Engineers Comments Regarding Surface Water Drainage

Subject: Planning Consultation on: WA/21/21/DOC

Application No:	WA/21/21/DOC
Registered:	15th March 2021
Site Address:	Wandleys Farm Wandleys Lane Walberton BN18 0QR
Description of Works:	Approval of details reserved by condition imposed under ref APP/C3810/W/18/3209249 (WA/76/17/PL) relating to Condition Nos 3 - materials & finishes, 4 - surface water drainage, 5 - Written Scheme of Investigation, 7 - hard & soft landscaping and 8 - Construction Method Statement

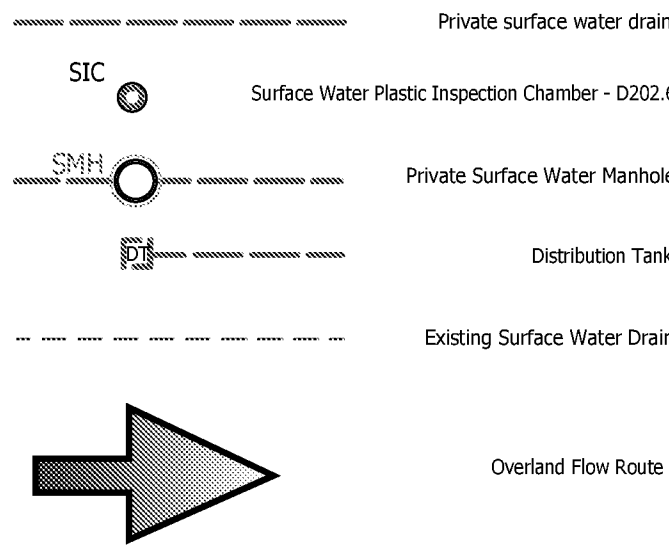
1. Please provide an impermeable area plan.
2. Please mark out the two different Hydrobrake model numbers on the drainage layout.
3. Please provide surveyed levels for the watercourse invert and top of bank. Please also model for a surcharged outfall. (Water at top of bank)

4. Please include a note to state what type of pipes are proposed (material). If the materials vary across the site, state as such.
5. Please include a note stating which cover types to use on inspection chambers/manholes on the drainage layout.

6. Please include sumps or silt traps upstream of all connections to permeable paving.
7. No construction detail drawings have been provided, please provide the following construction detail drawings:

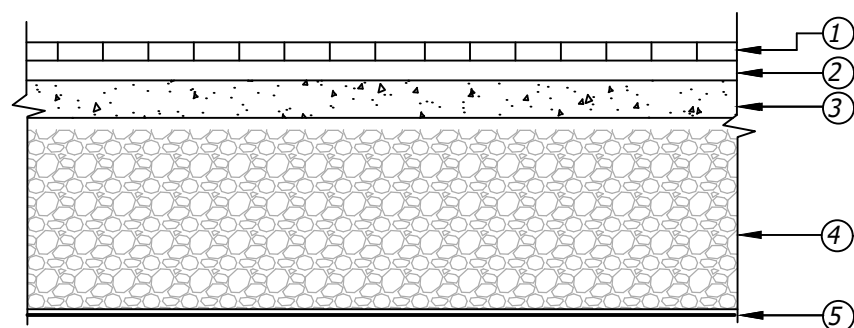
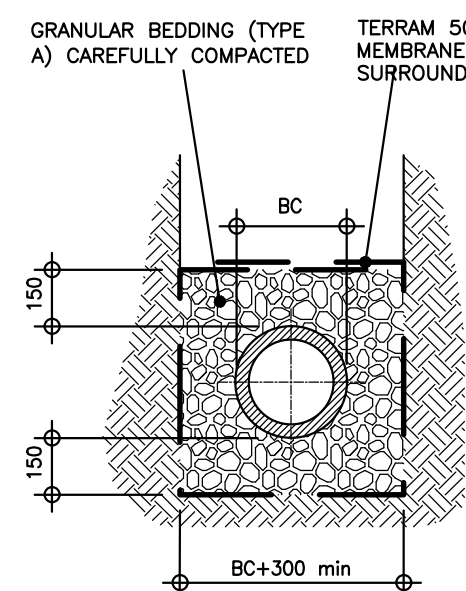
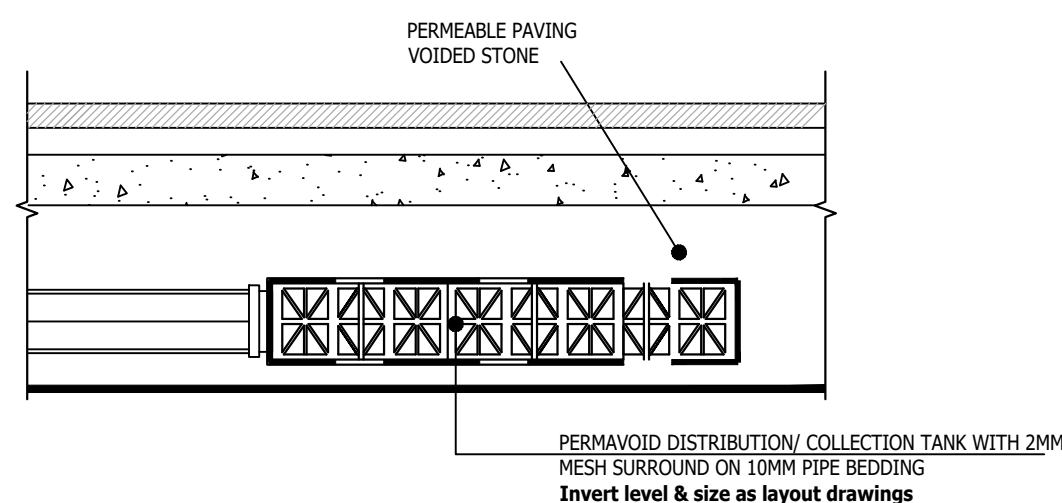
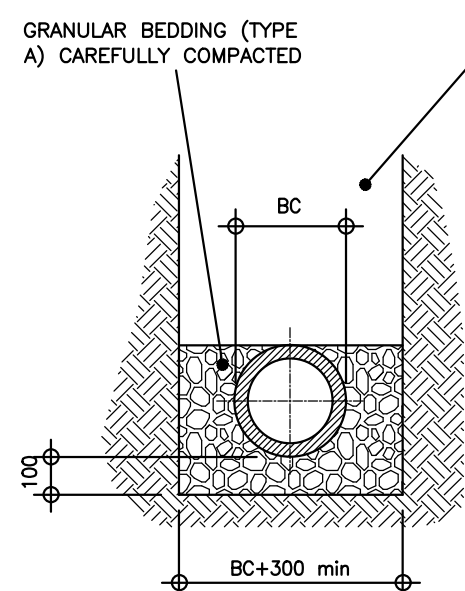
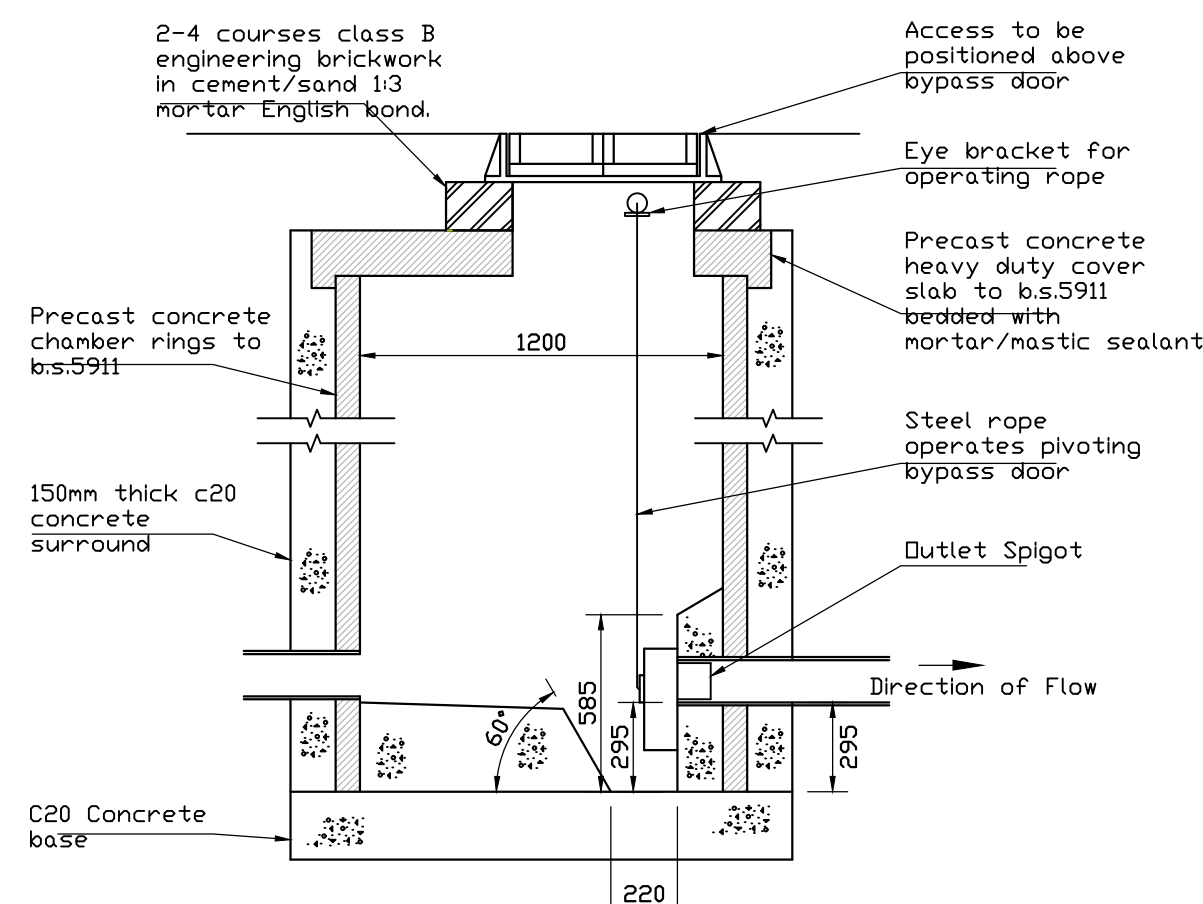
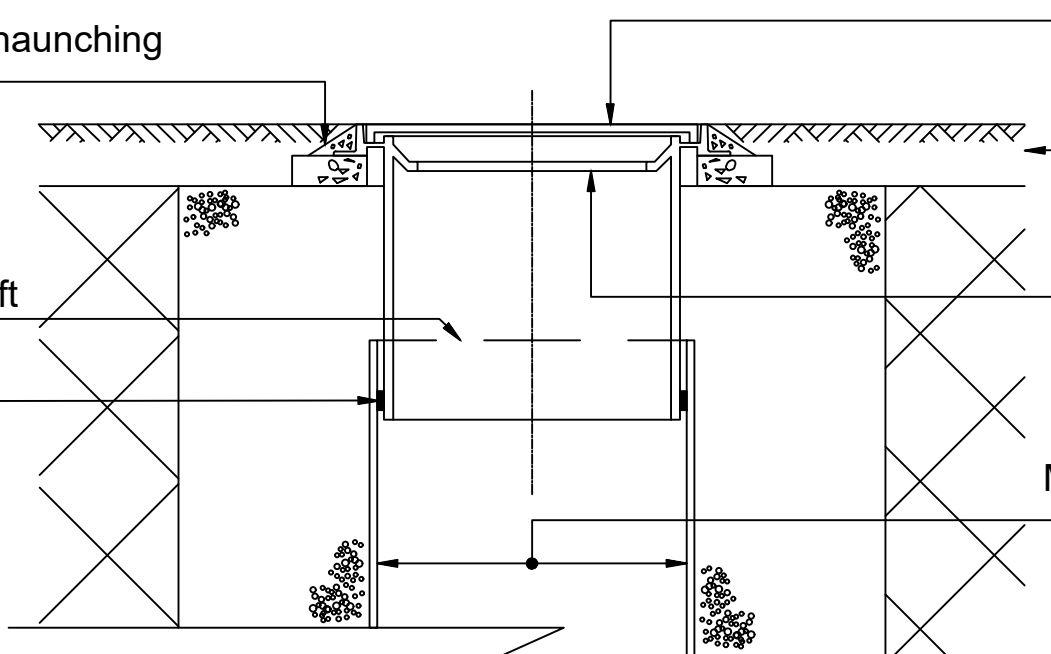
- a) Pipe bed and surround
 - b) Permeable paving including diffuser blocks.
 - c) Manholes/inspection chambers/silt traps
 - d) Both different hydrobrakes, in accordance with the calculations.

- e) Headwall to the watercourse
